A1 in Northumberland: Morpeth to Ellingham

Scheme Number: TR010059

7.25 Applicant's Comments on Responses to Further Written Questions

**Applicant's Comments on Responses to Further
Written Questions**

**Trees to be Removed and Replaced at Coronation Avenue  
WQ LV.1.8**

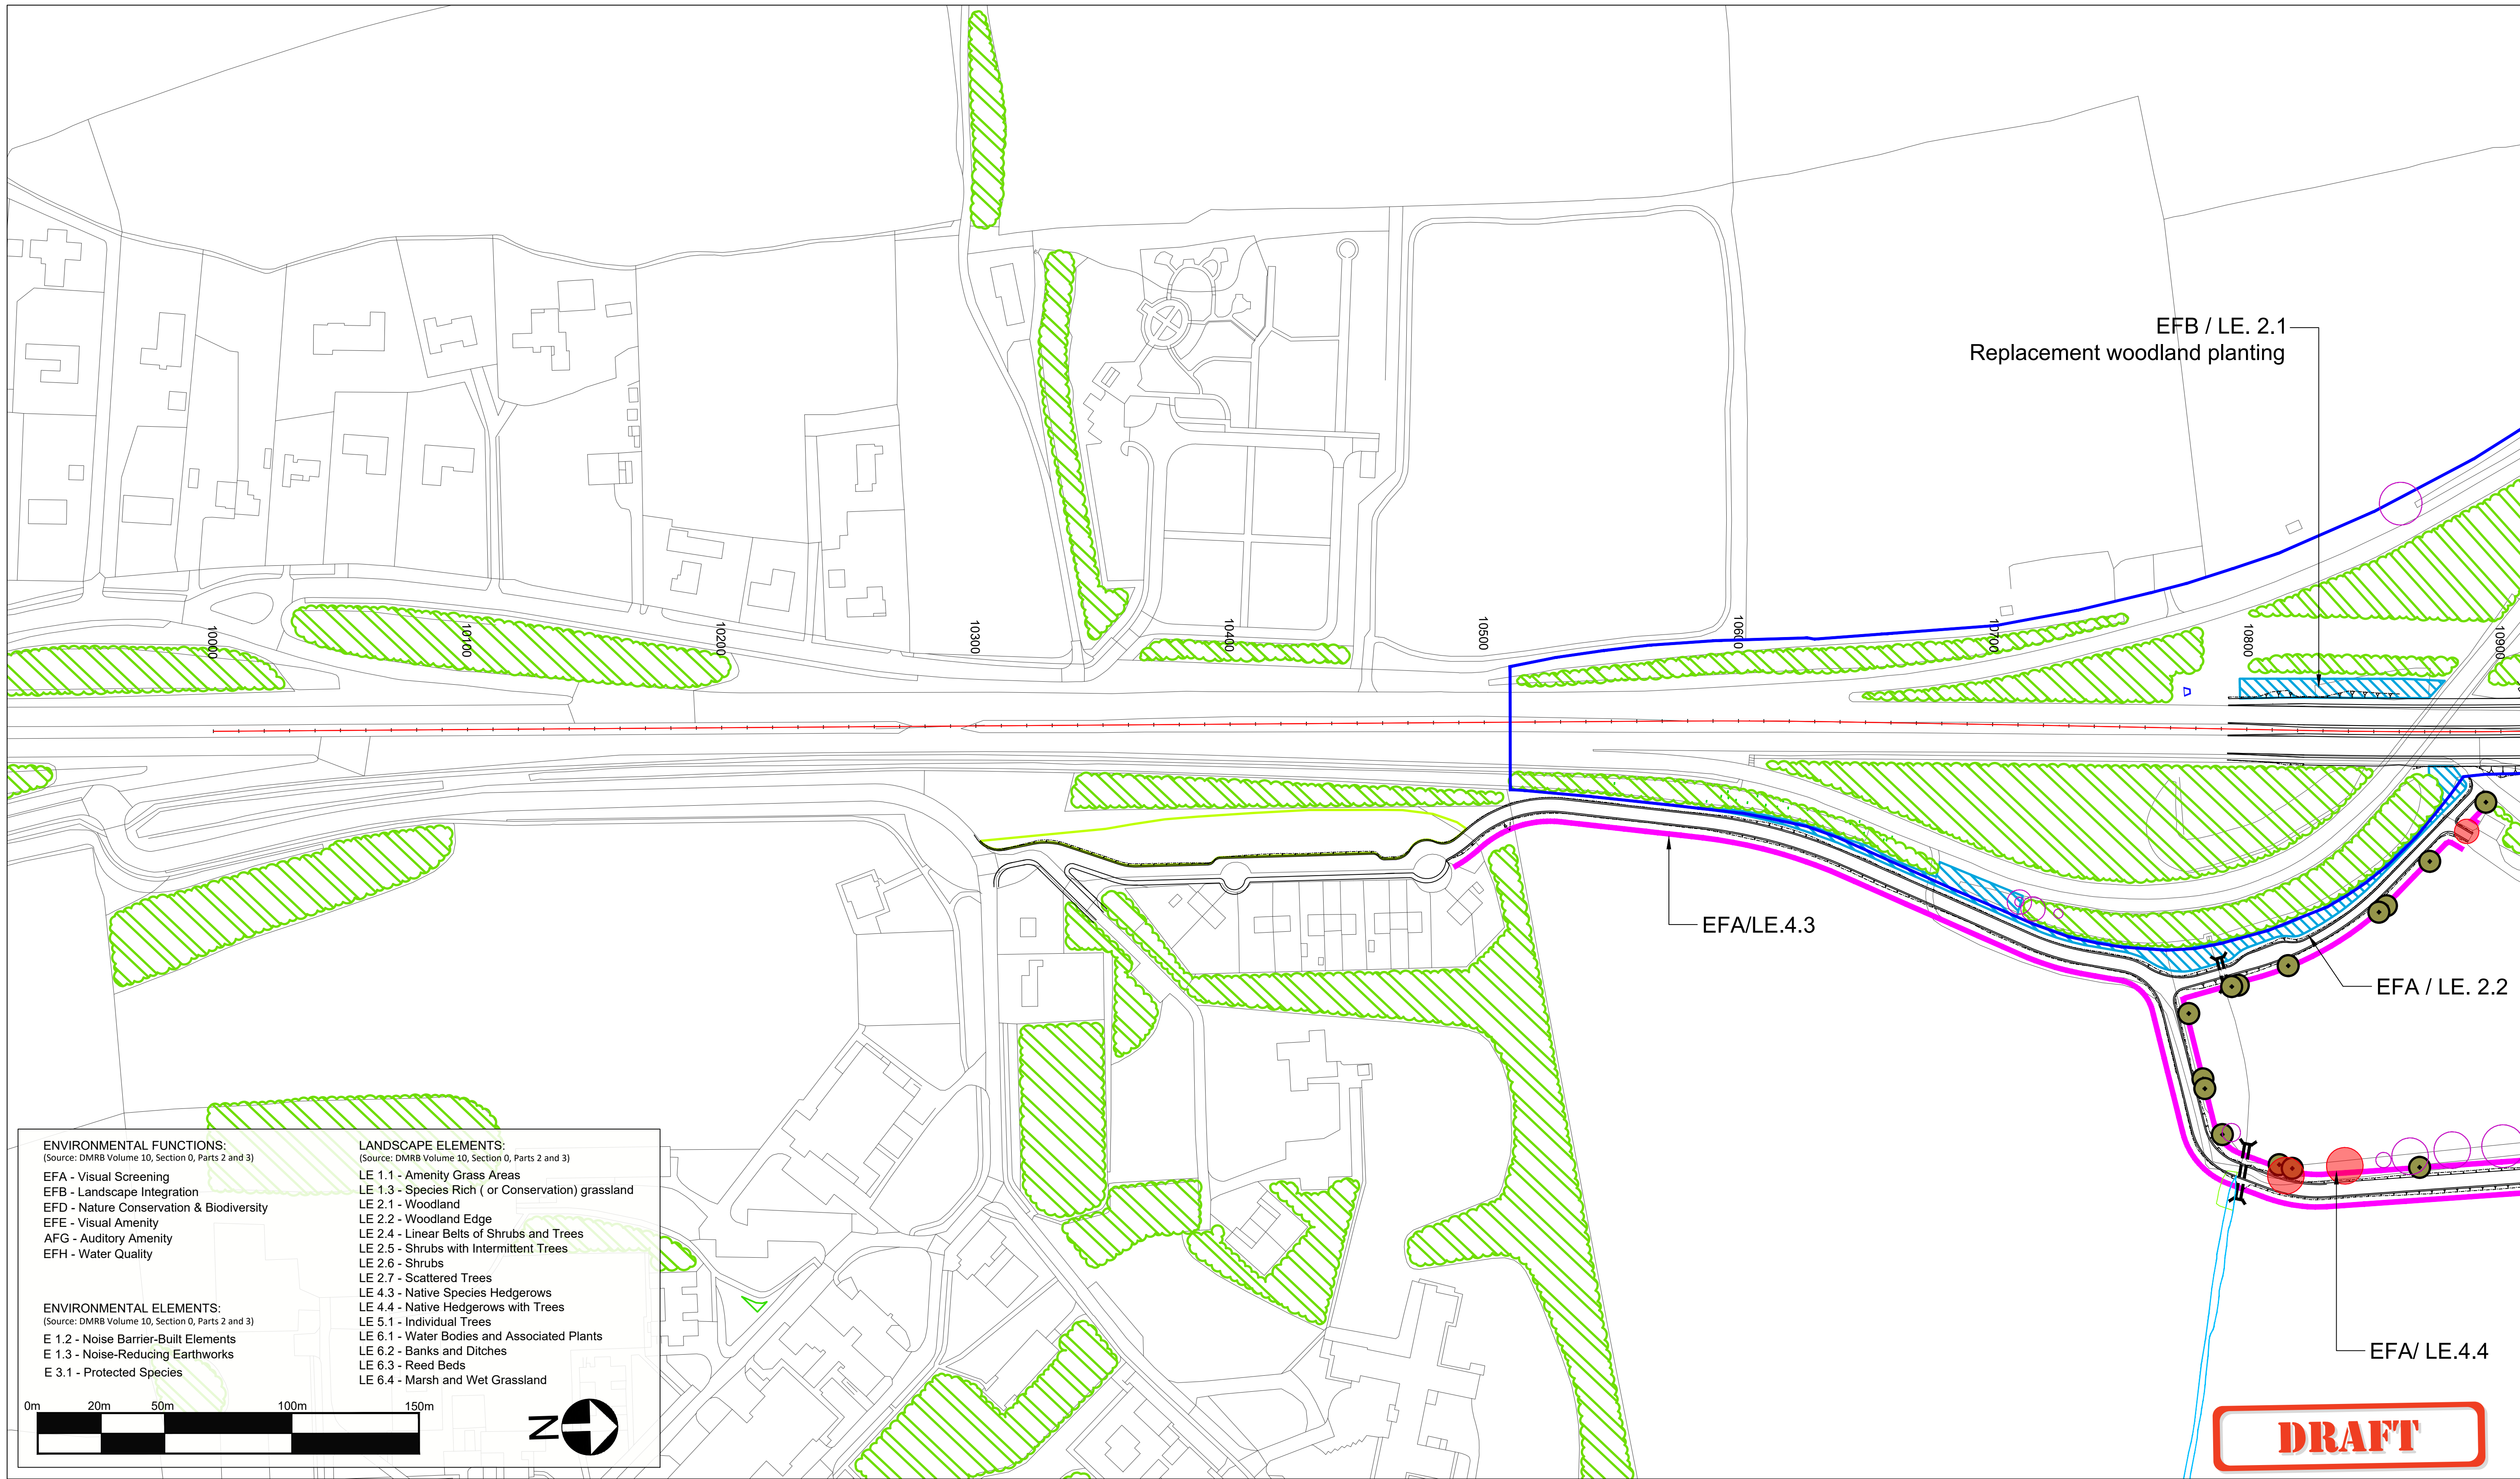
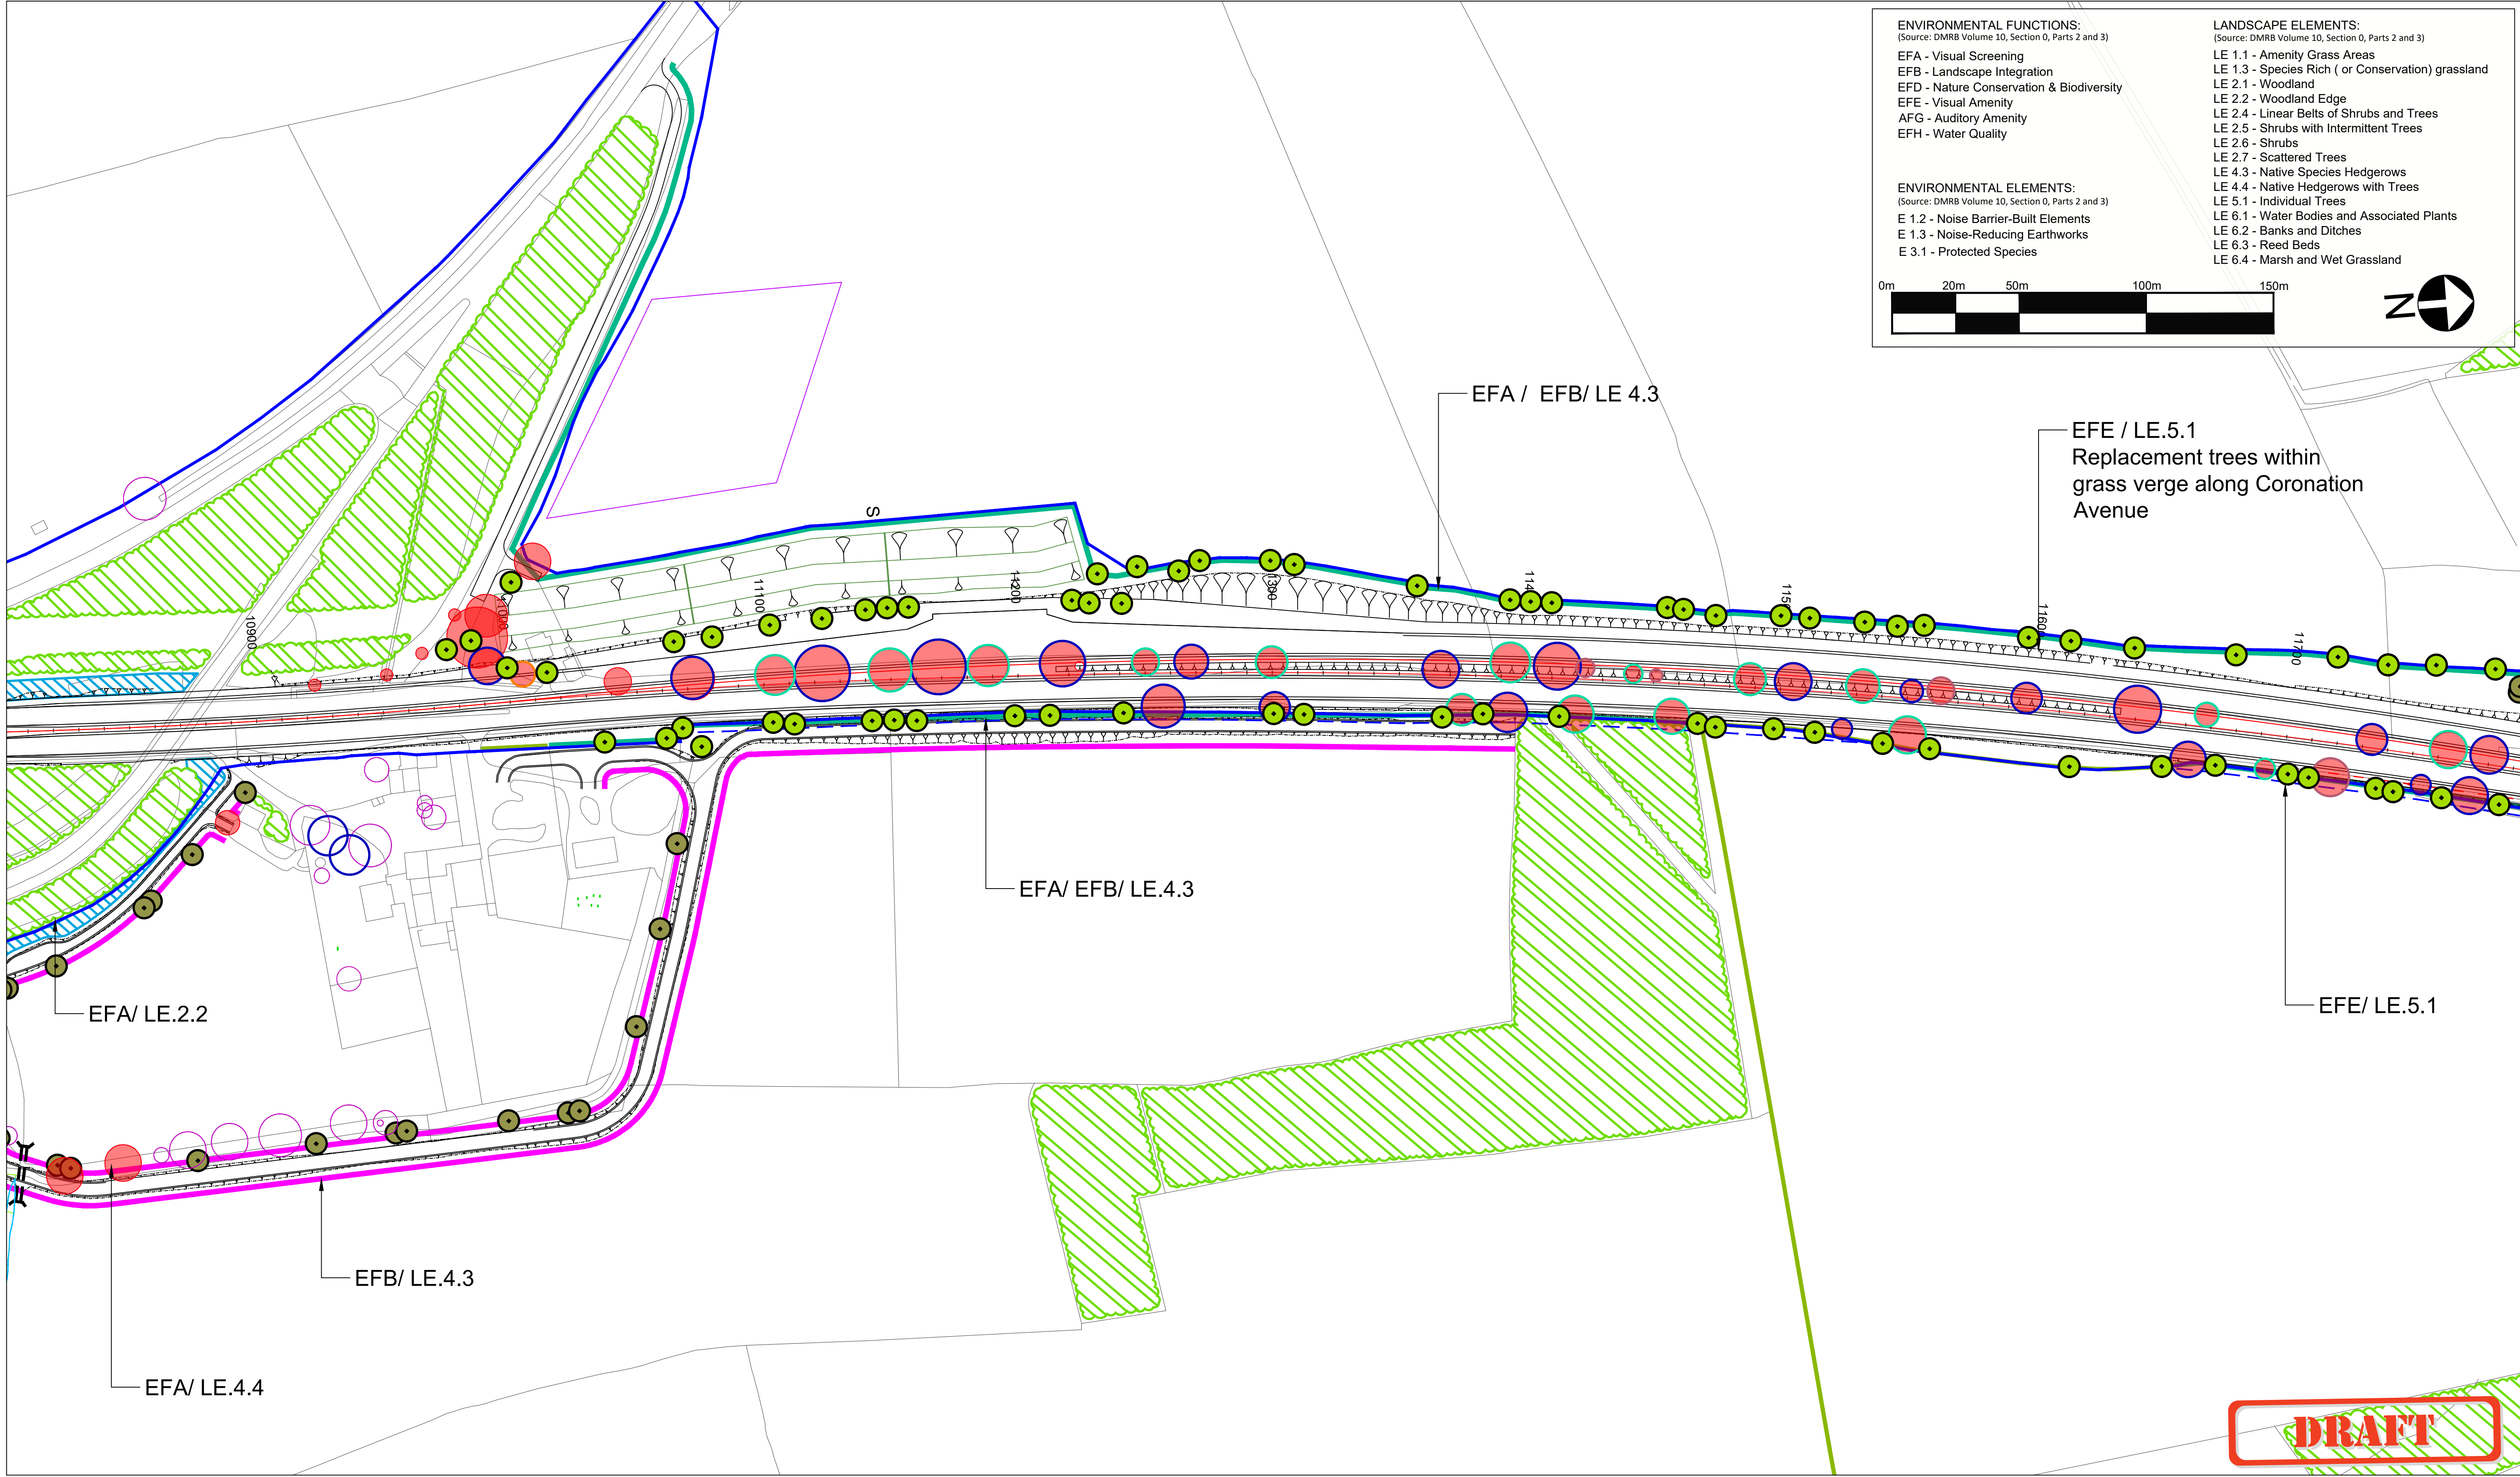
Ref. No.	Question to	Question	Interested Party's Response	Applicant's Response
LV.2.2 1.	Applicant IPs	The plans which form Appendix LV.2 Trees to be Removed and Replaced at Coronation Avenue WQ LV.1.8 [REP1-044] are annotated 'Draft'. The Applicant is asked to explain how this relates to the requirement in R5(3) of the dDCO for the landscaping scheme to include a strategy for the replacement of trees which are to be removed at Coronation Avenue? IPs are asked to comment on the proposals for Coronation Avenue.	In reviewing this documentation again, I remain disappointed by the scale of tree loss inflicted by the scheme. Undoubtedly the biggest impact is on the distinguished Coronation Avenue of trees which line both sides of the single carriageway. I am not aware of any other A classed road in the country which can boast such an extensive configuration of mature trees, which are now approaching 70 years age. The main source of frustration stems from an underlying belief that more could have been done to protect the trees and improve the levels of mitigation. For example, most of the work carried out on the existing road is asymmetric which means that the	<p>1. The removal of the trees at Coronation Avenue is necessary in order to construct the Scheme, either through direct loss of the trees or impacts on their roots that in the long term would reduce their viability. The removal of vegetation would be avoided where possible to safeguard any remaining trees, including those that make up the Coronation Avenue. This is secured through item SL-2 of Table 3-1 - Register of Environmental Actions and Commitments: The Scheme in Outline CEMP [REP5-012 and 013] (and as updated at Deadline 6).</p>

2.			<p>In total it appears that circa 200 coronation trees are to be felled and replaced with young trees which I understand will take a minimum of 15 years to mature. Even then the visual impact and environmental contribution will remain well short of what we enjoy today.</p>	<ol style="list-style-type: none"> 1. The Scheme would require the removal of existing roadside hedgerows and removal of 187no. existing trees that form the Coronation Avenue of trees. 2. The replacement of trees would be undertaken using advanced nursery stock, and this is secured through item SL-4 of Table 3-1 - Register of Environmental Actions and Commitments: The Scheme in Outline CEMP [REP5-012 and 013] (and as updated at Deadline 6). What this means in practice is that the trees would be of larger size when planted, being a minimum of 3m in height. The final height of the tree will depend upon the species selected. 3. It should be noted that trees will establish and grow continually until they reach maturity. The reference to 15 years is taken from the guidance for landscape and visual assessment, DMRB 135/10, a link to which is provided within Applicant's Responses to the ExA's Further Written Questions - Appendix C - Former and Updated DMRB Guidance [REP5-026]. This requires the assessor to consider the impact of the Scheme in the summer of year 15, when it is assumed that for the most part the planting will have sufficiently established in order to fulfil its function as mitigation. Trees, including those planted to replace the Coronation Avenue will continue to mature up to and beyond year 15. However, in the meantime

3.			<p>In looking at the plans for the new arrangement of replacement trees the Avenue effect would appear to have been lost. The configuration of the trees is no longer linear and there are too many gaps in the flow to emulate the Avenue effect. Furthermore, the distances between the trees flanking each side of the road are over 50 metres in some cases.</p>	<p>1. The strategy for the replacement of the Coronation Avenue, as agreed with NCC, is shown on Landscape Mitigation Masterplan Part A for Change Request Rev 3 [REP4-060], and secured through item S-L2 (c) of Table 3.1 – Register of Environmental Actions and Commitments: The Scheme in the Outline CEMP [REP5-012 and 013] (and as updated at Deadline 6). The strategy for the replacement of the trees that contribute to the Coronation Avenue would be on a like for like basis in terms of numbers and would replace the important landscape feature that would be impacted by Part A with an informal avenue effect, rather than 'pairs' of opposing trees, and which would be similar to what is currently experienced. This is identified in paragraph 7.9.14 (a) of Chapter 7: Landscape and Visual Part A [APP-044]. The replacement trees would also comprise more advanced nursery stock (and would therefore be larger and more discernible than transplants, which would make up the bulk of the mass planting of woodland and scattered trees), this is identified in paragraph 7.9.14 (h) of Chapter 7: Landscape and Visual Part A [APP-044].</p> <p>2. The replacement planting along the wider corridor would increase the width between the lines of trees either side of the Scheme. However, the replacement strategy is such that, over time, the tree lined nature</p>

Ref. No.	Question to	Question	Interested Party's Response	Applicant's Response
				<p>of the corridor would be substantially restored to form an informal avenue that would be a key feature of the view travelling along the A1, similar to what is experienced currently. The replacement strategy is identified on Landscape Mitigation Masterplan Part A for Change Request Rev 3 [REP4-060] submitted at Deadline 4, and secured through item S-L2 (c) of Table 3.1 – Register of Environmental Actions and Commitments: The Scheme in the Outline CEMP [REP5-012 and 013] (and as updated at Deadline 6). As such, the informal avenue effect would over time be restored.</p>
LV.2.6 1.		Appendix LV3 Response to LV.1.13 [REP1-051] considers potential additional mitigation measures, their suitability and the prospect of potentially reducing significant effects to non-significant. What are the views of IPs in respect of these further potential mitigation measures?	Although the opening paragraph does make the claim that additional mitigation may reduce significant effects to non-significant, I could not find any example in the rest of the document which suggested that this had been achieved.	<ol style="list-style-type: none"> 1. Within Appendix LV3 Response to LV.1.13 [REP1-051] consideration was given as to whether additional mitigation might reduce significant effects to non-significant. The Applicant reviewed the mitigation strategy for those receptors where a significant effect was anticipated to remain following construction of the Scheme and considered whether the effect could be reduced should further measures be identified. The conclusion of that review for all locations assessed was that further screening, in the form of planting or fences, would not provide sufficient mitigation or might in themselves result in impacts on views and/or changes to landscape character. As such, further screening is not proposed as part of the Scheme.
